SAVE OUR SANDLINGS

**Offshore Wind Farms
EAST ANGLIA ONE NORTH PINS Ref: EN010077
&
EAST ANGLIA TWO PINS Ref: EN020078**

**Applicant Deadline 3
Important Hedgerow & Trees
Preservation Plan**

Submission for Deadline 4

| | Sheet Number: Sheet 1 of 12 | | | | | | | | | | | |

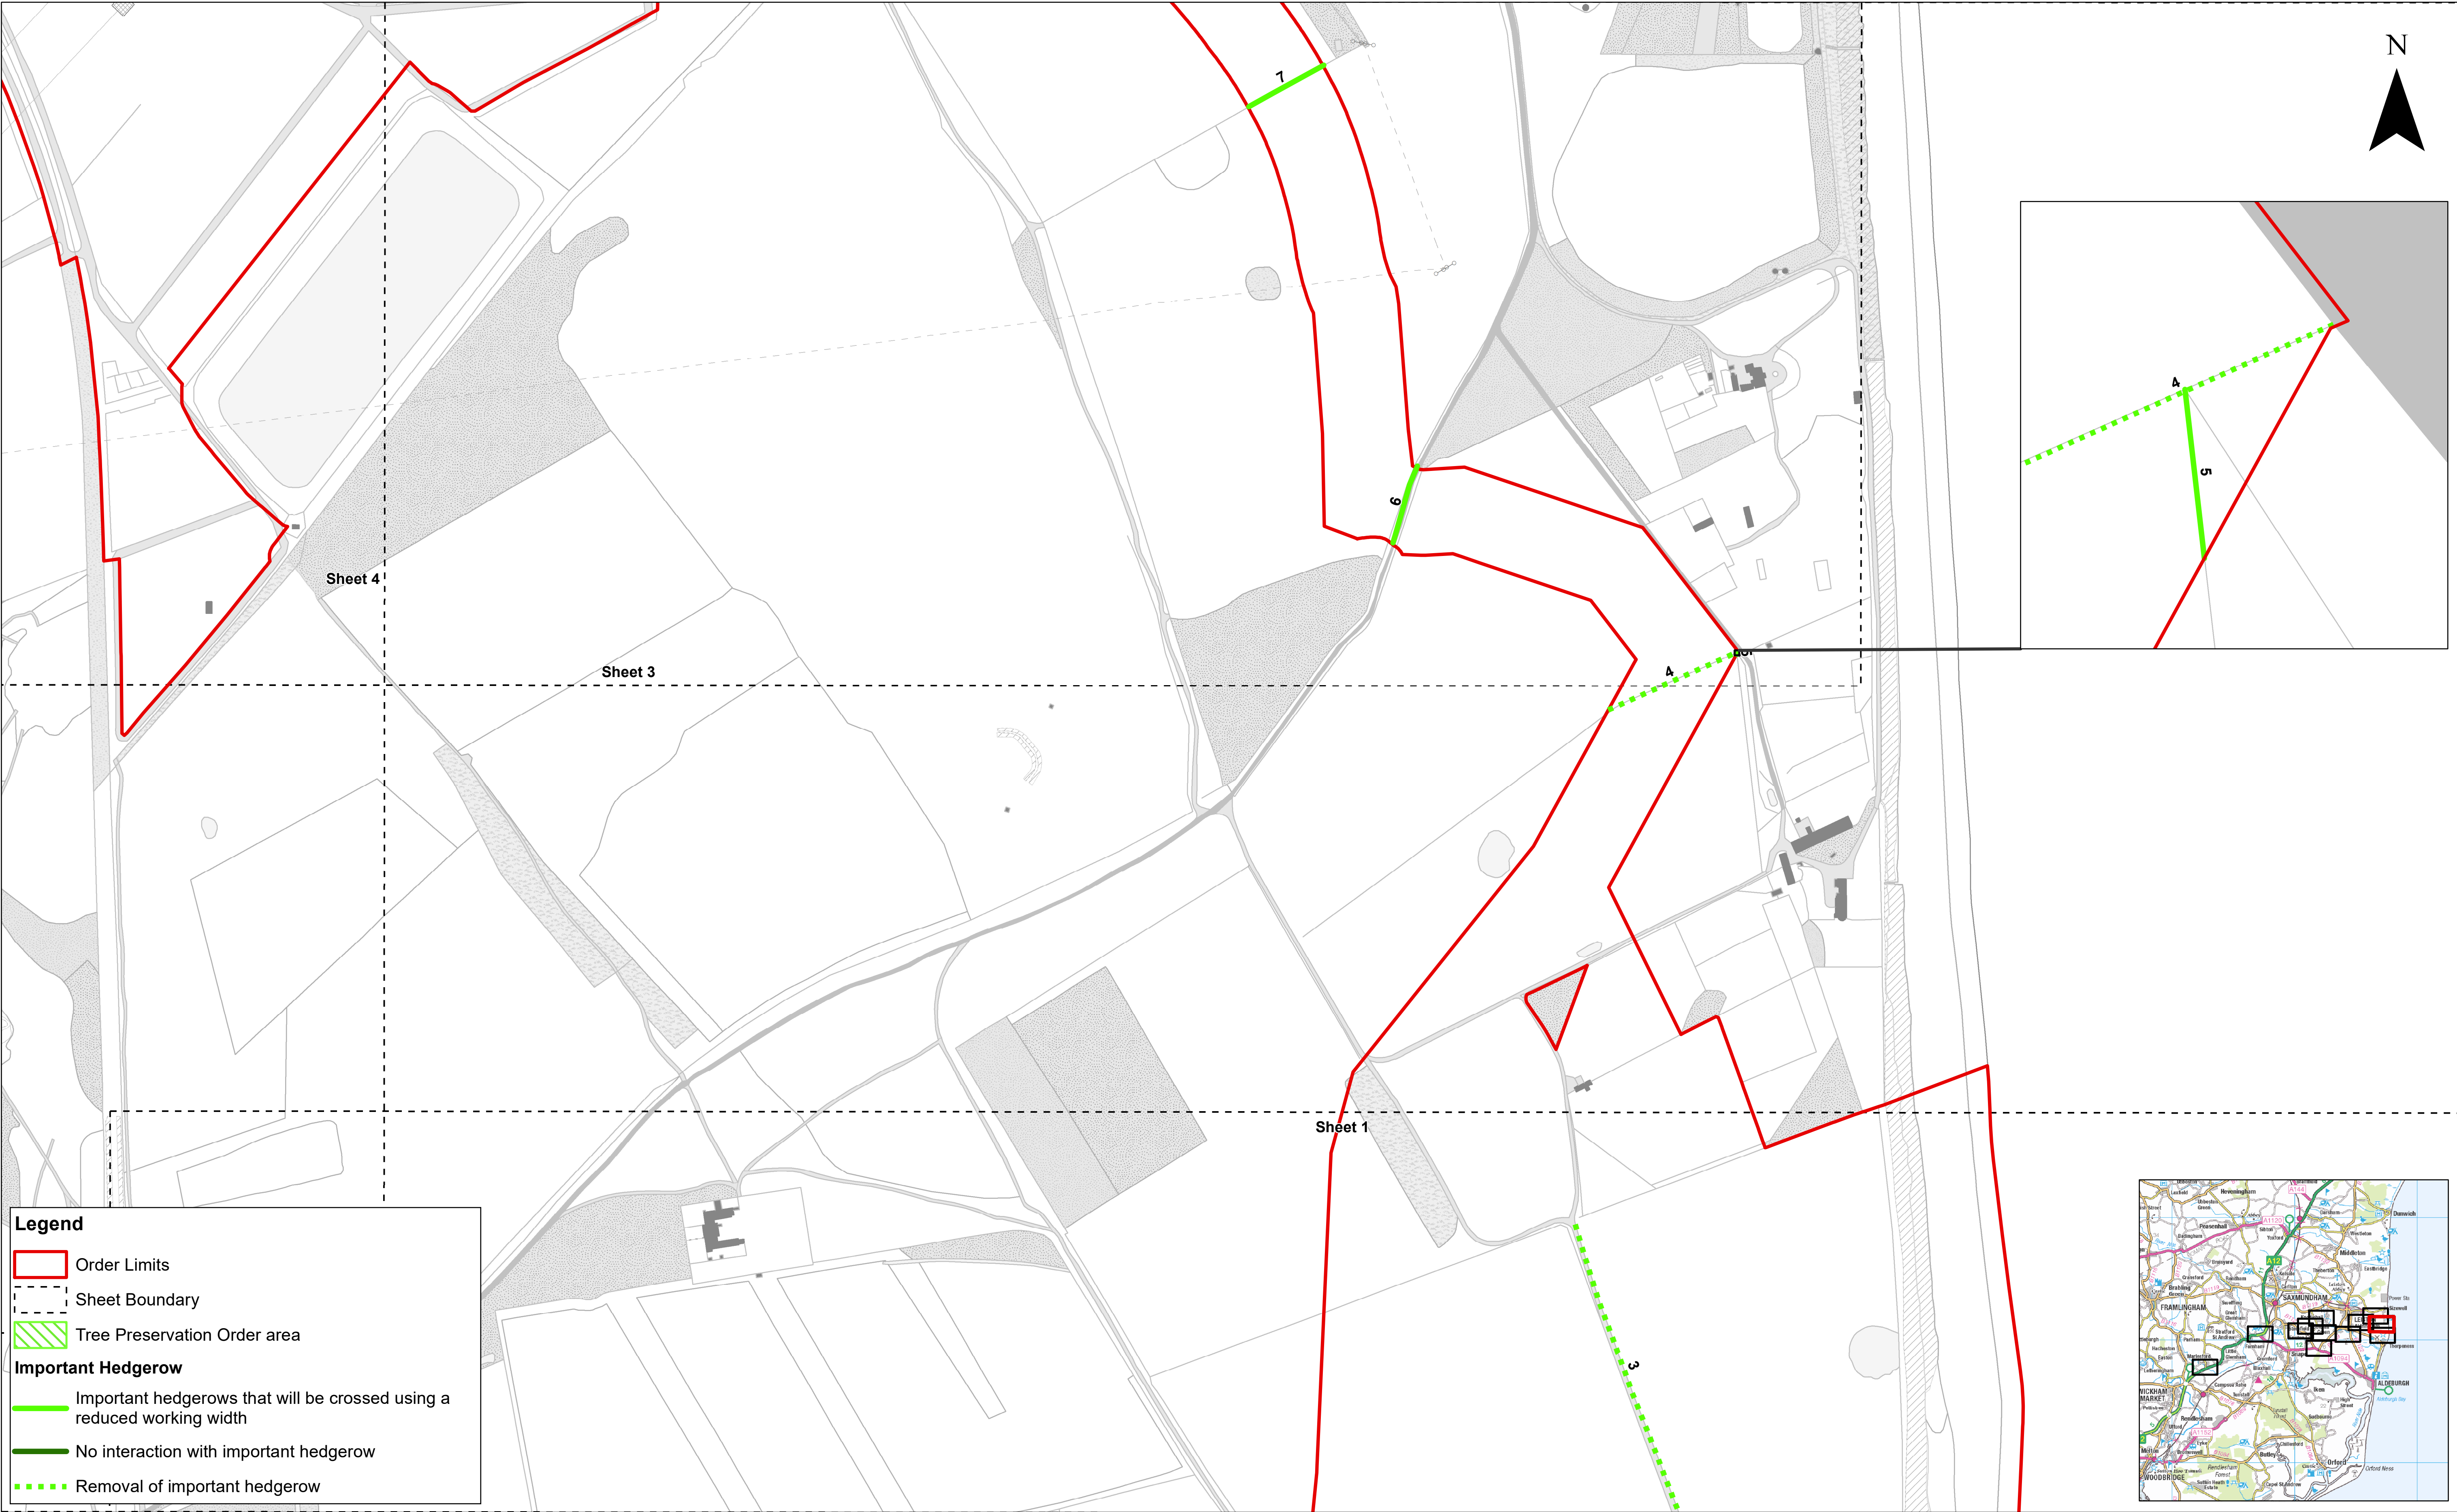
Hedgerow 1 ¹

We are very concerned at the potential loss of important hedgerow Temp 1, E-106/020/0 ²
³. This forms part of the Holloway, Footpath 20 .

A hollow way⁴ or sunken lane are centuries-old thoroughfares worn down by the traffic of time. They're one of the few examples of human-made infrastructure still serving its original purpose, although many who walk through Holloways don't realise they're retracing ancient steps. We object most strongly to the desecration and vandalism of an ancient trackway when a suitable and viable alternative exists in close proximity.

Where FP20 meets Thorpeness Common, there is a vehicle track circumnavigating the common. Whilst we deplore the removal of any hedgerow, a suitable opening could be made from Works 7 to access this track and then access Works 8 directly. Whilst this would result in the loss of 2 sections of hedgerow, damage to an ancient trackway **would be prevented**.

| Important Hedgerows and Tree Preservation Order Plan Sheet Number: Sheet 2 of 12 | | | Rev | 5 | British National Grid OSGB36 |

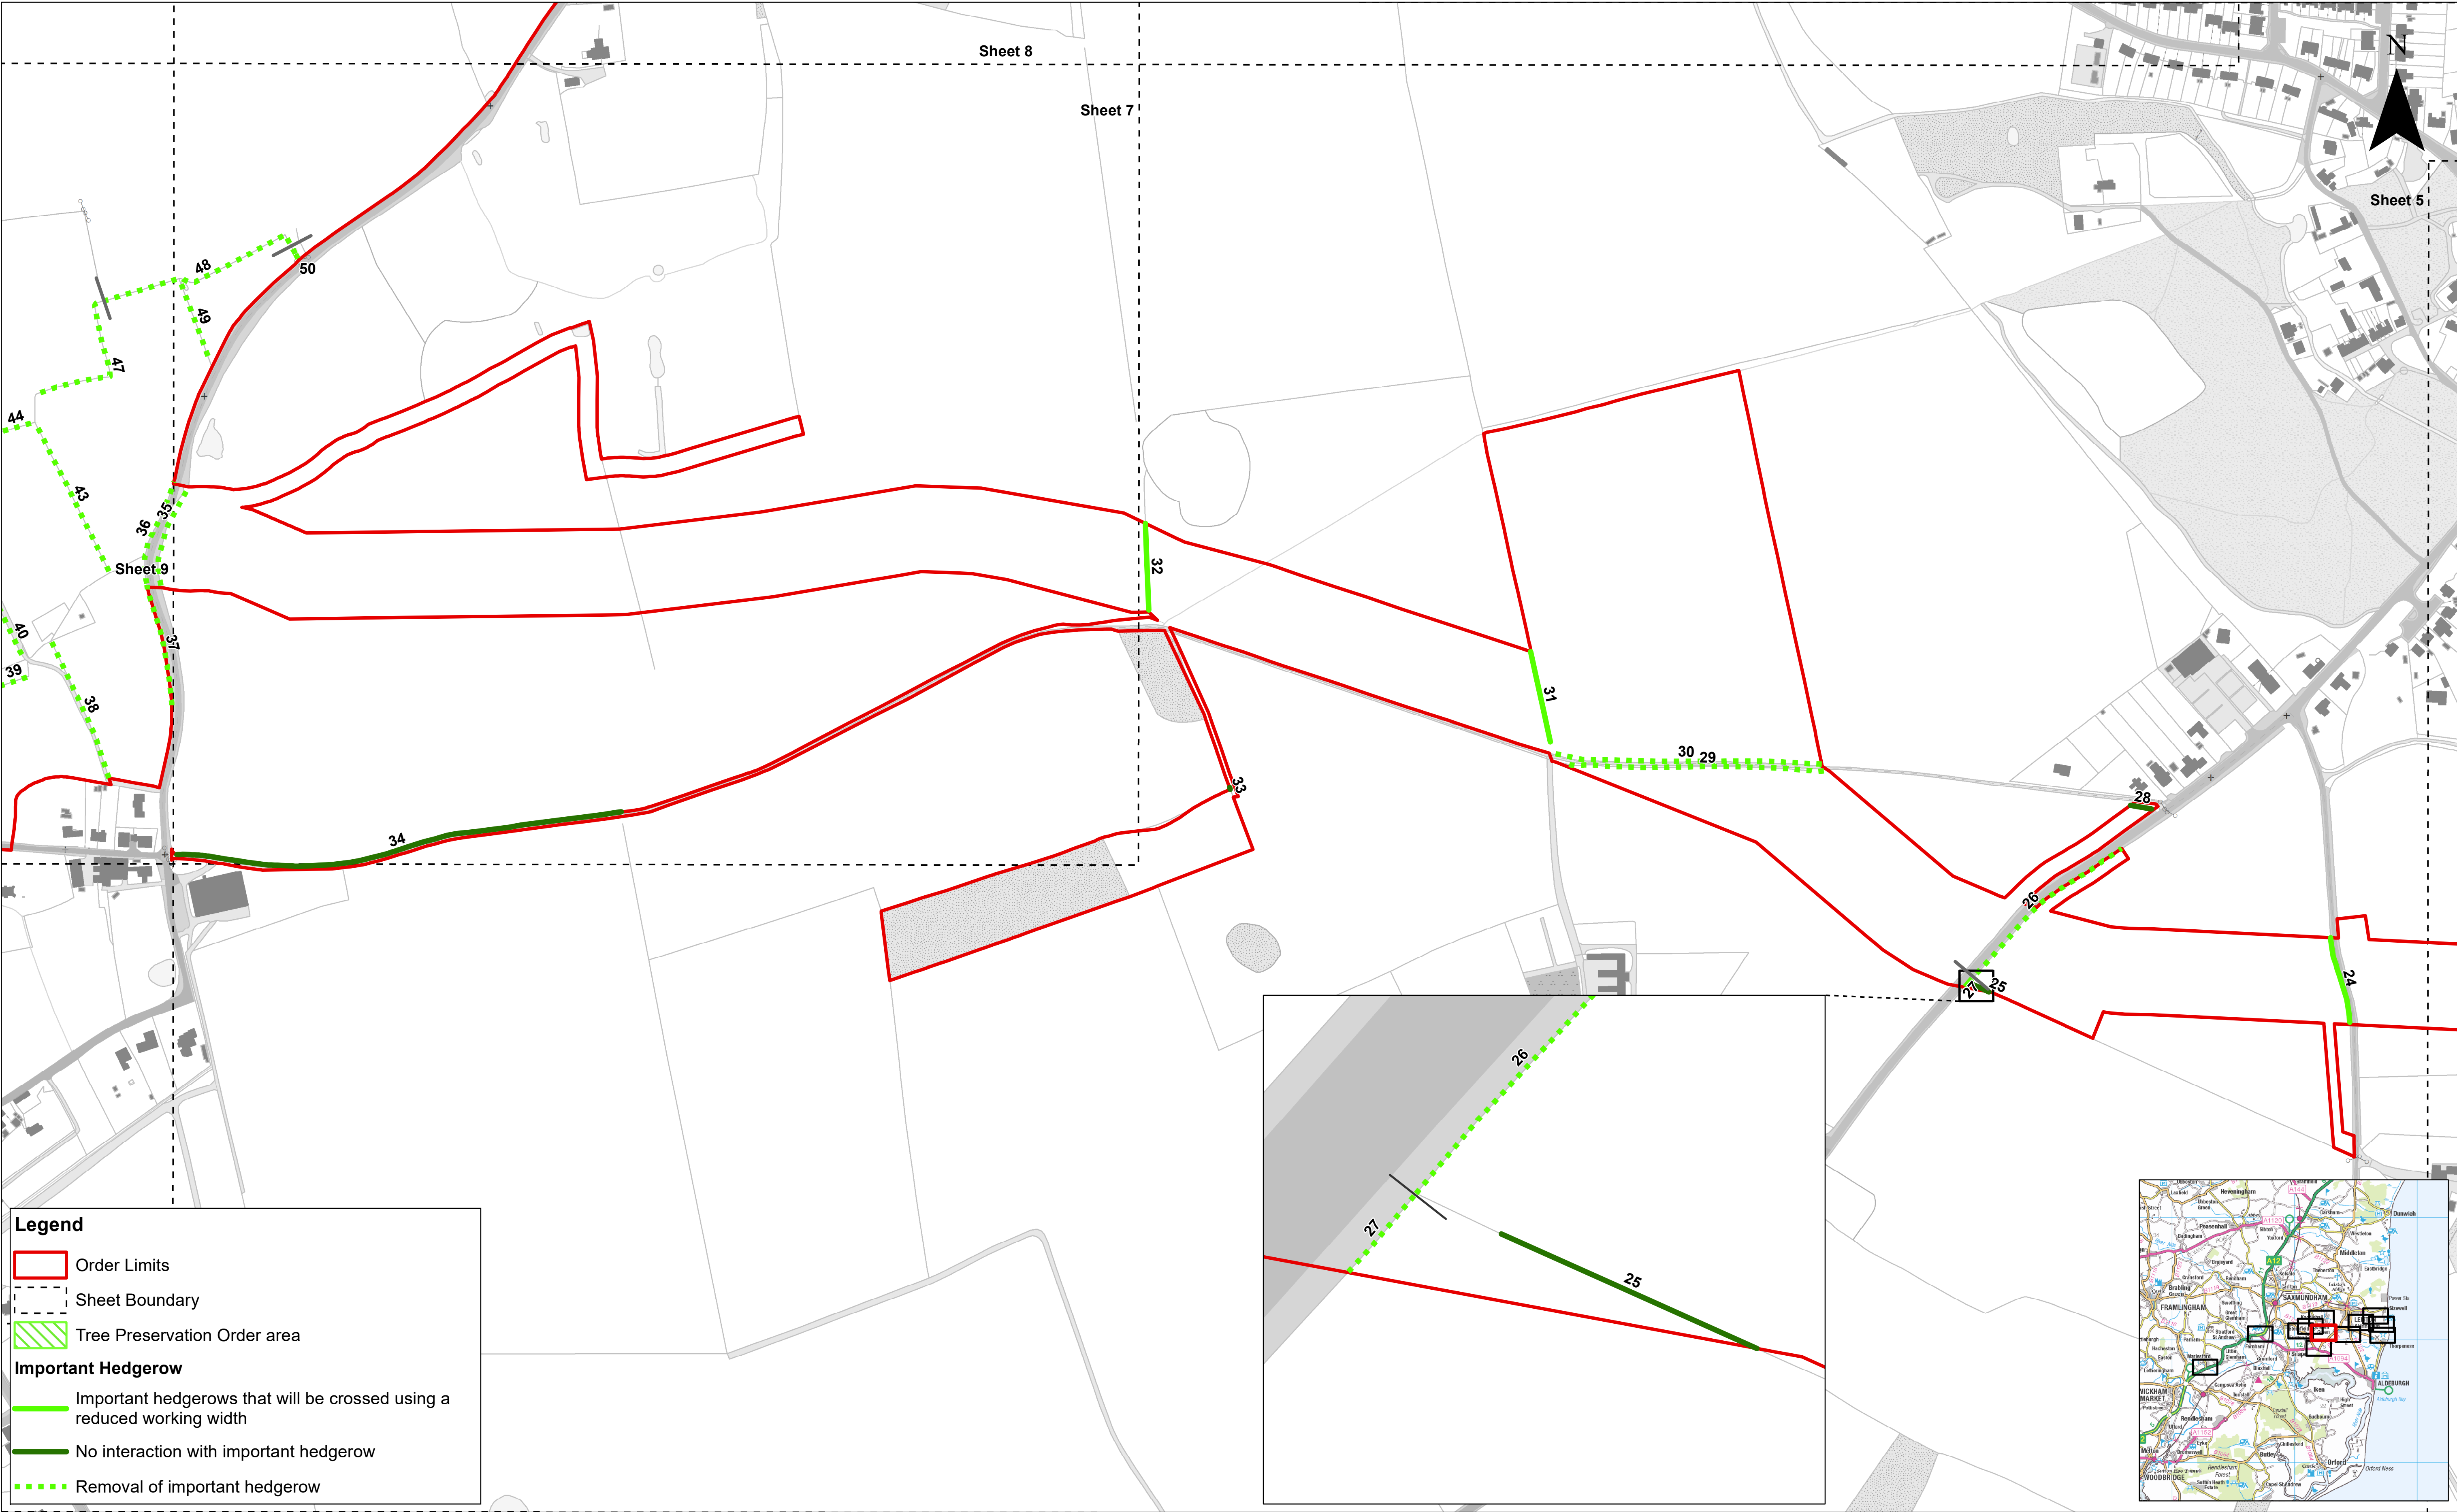
Hedgerow 3 4 and 5 ⁵

Similarly, the removal of Important Hedgerows 3 and 4 should be avoided where ever possible, especially in the case of hedgerow 3. To remove the entire length when there is sufficient land either side to accommodate project activities appears to be chosen as a result of lazy planning, an easy option. These hedgerows serve an important purpose not only for wildlife as refuge corridors for many smaller species, but also attracting many the many insects who are a vital crop pollinators and food source for birds etc.. Hedgerows act as essential wind barriers, especially hedgerow 3 as it is in a North/South alignment moderating the coastal winds and preventing excessive soil creep, especially important in the Sandlings area of extremely fine soil particles.

The crossing of hedgerow 5 should be limited to least width possible or avoided completely as this is a North/South alignment and is important for the reasons highlighted above.
